Advice to decision maker on coal mining project

IESC 2019-105: Dendrobium Mine – Plan for the future: Coal for steelmaking (EPBC 2017/7855 and SSD 8194) – Expansion

Requesting agency	The Australian Government Department of the Environment and Energy and The New South Wales Department of Planning, Industry and Environment
Date of request	23 August 2019
Date request accepted	23 August 2019
Advice stage	Assessment

ILLAWARRA COAL
DENDROBIUM MINE - PLAN FOR THE FUTURE: COAL FOR STEELMAKING
GEOLOGICAL STRUCTURES IN THE WONGAWILLI SEAM

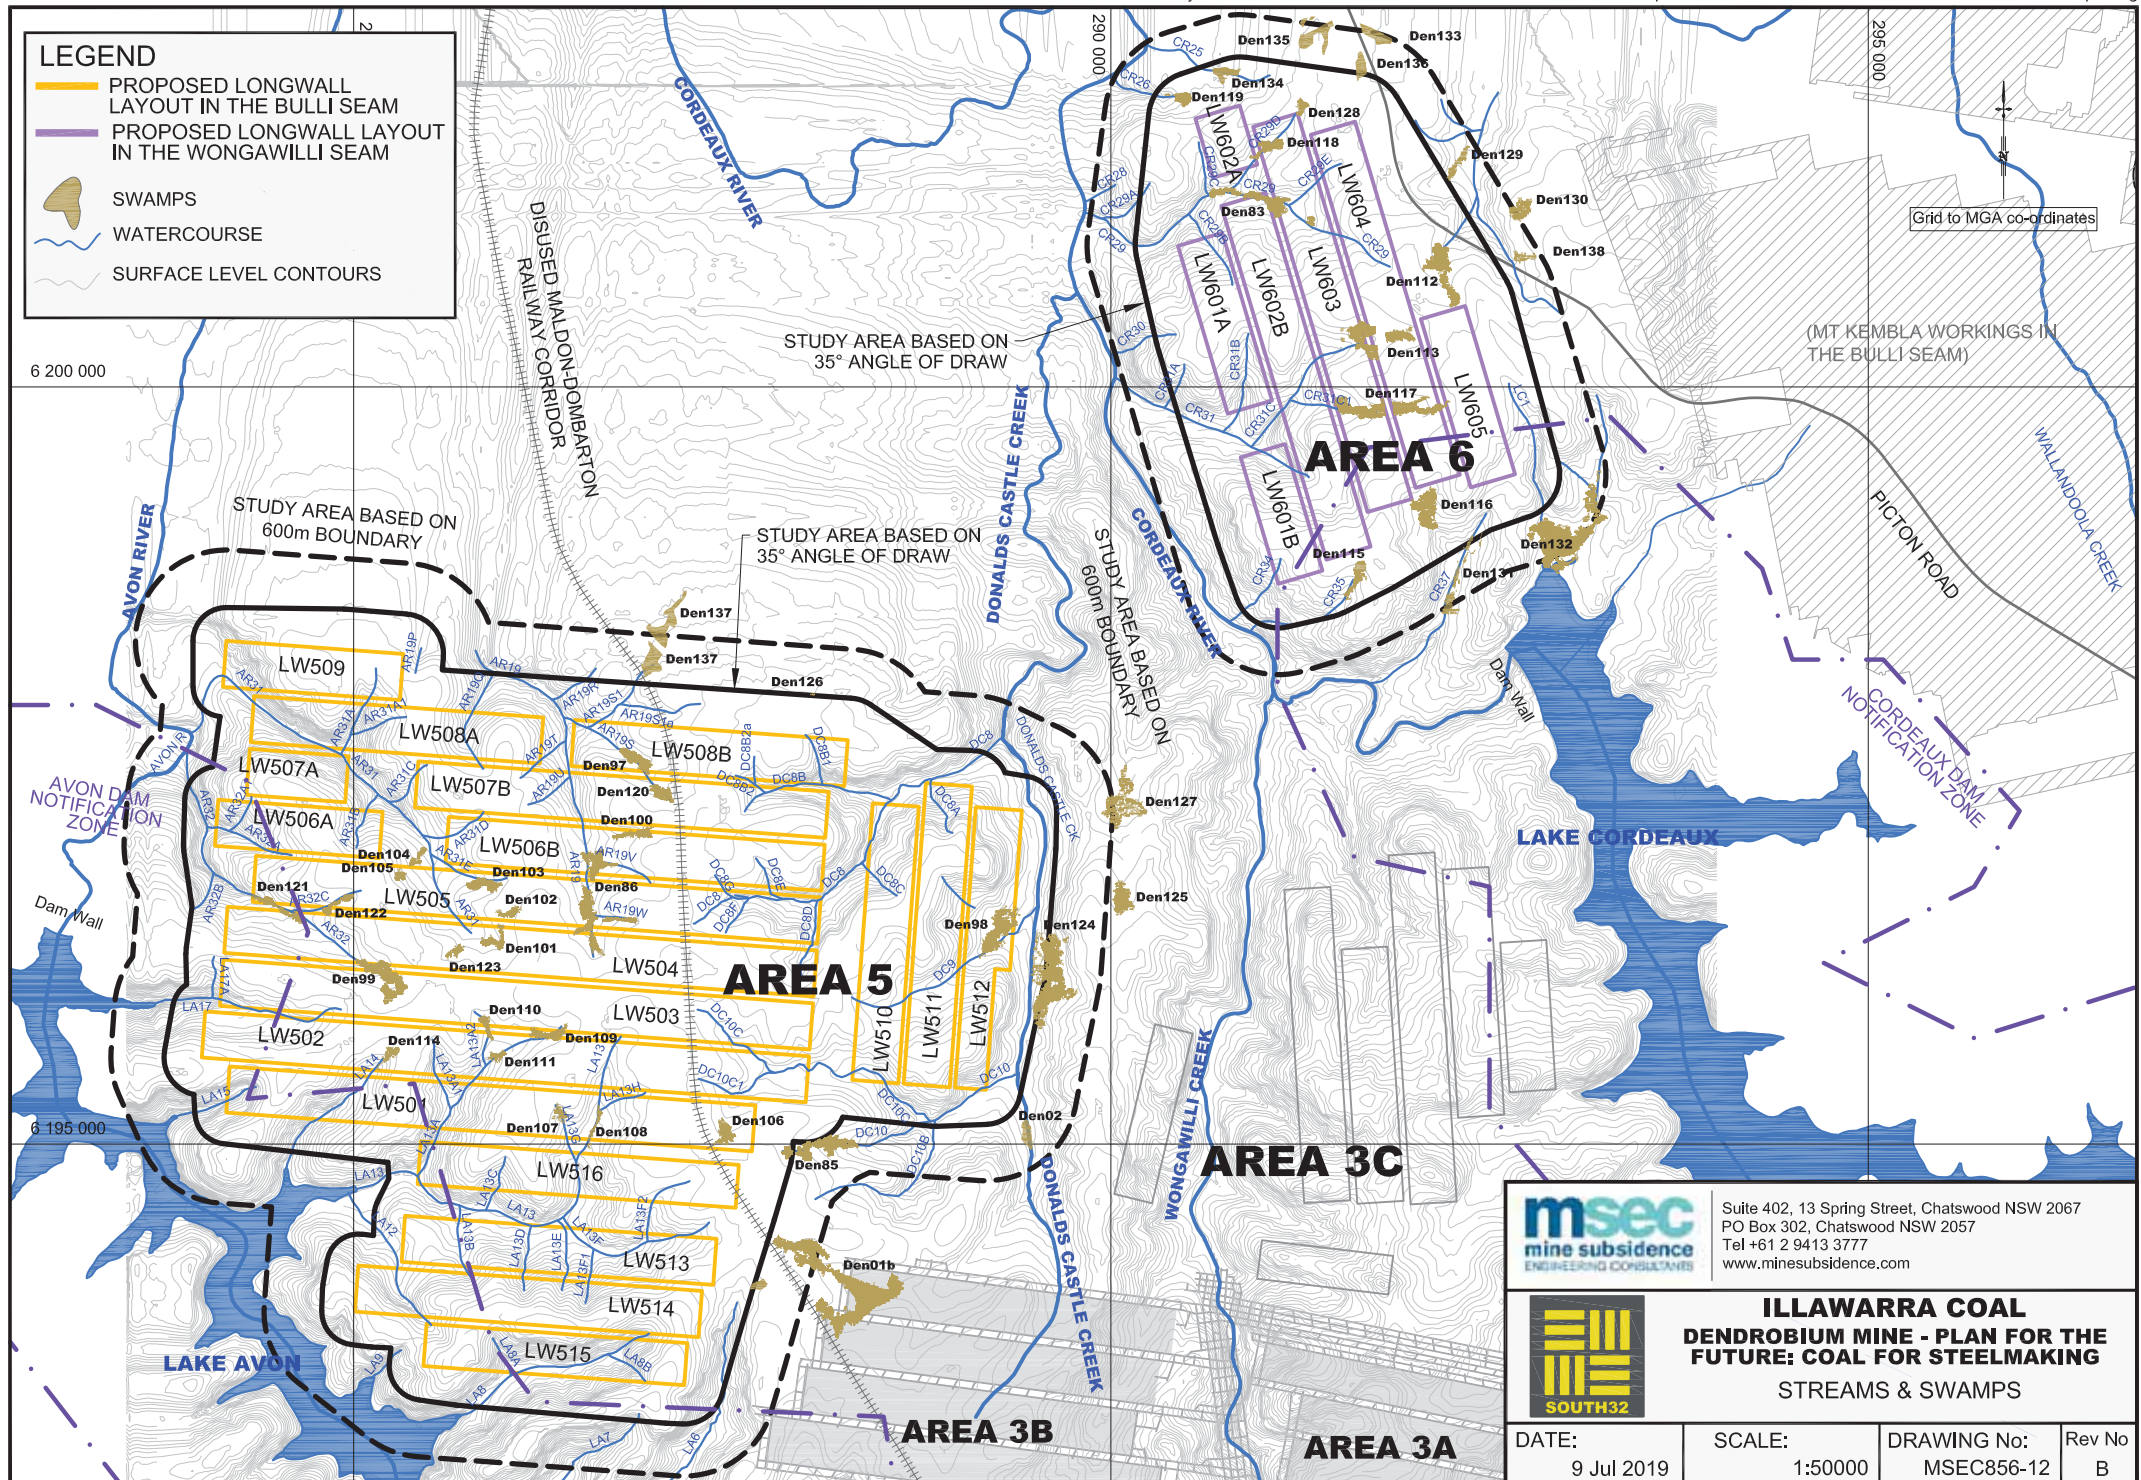
- d. It is also unclear whether the potentially significant Elouera Fault has been included in the groundwater model. The IESC also notes that aspects of the geological structure review do not appear to be included in the groundwater model, including:

- i. a significant zone of disturbance described as the Potential Bulli Fault (PSM 2019, pp. 4, 13);
 - ii. three regional faults inferred within Areas 5 and 6 (PSM 2019, p. 12); and

- iii. faults inferred in drawing 5 (PSM 2019).
 - e. Based on the above desktop analysis, further site specific investigations (e.g. geophysics) may be warranted.
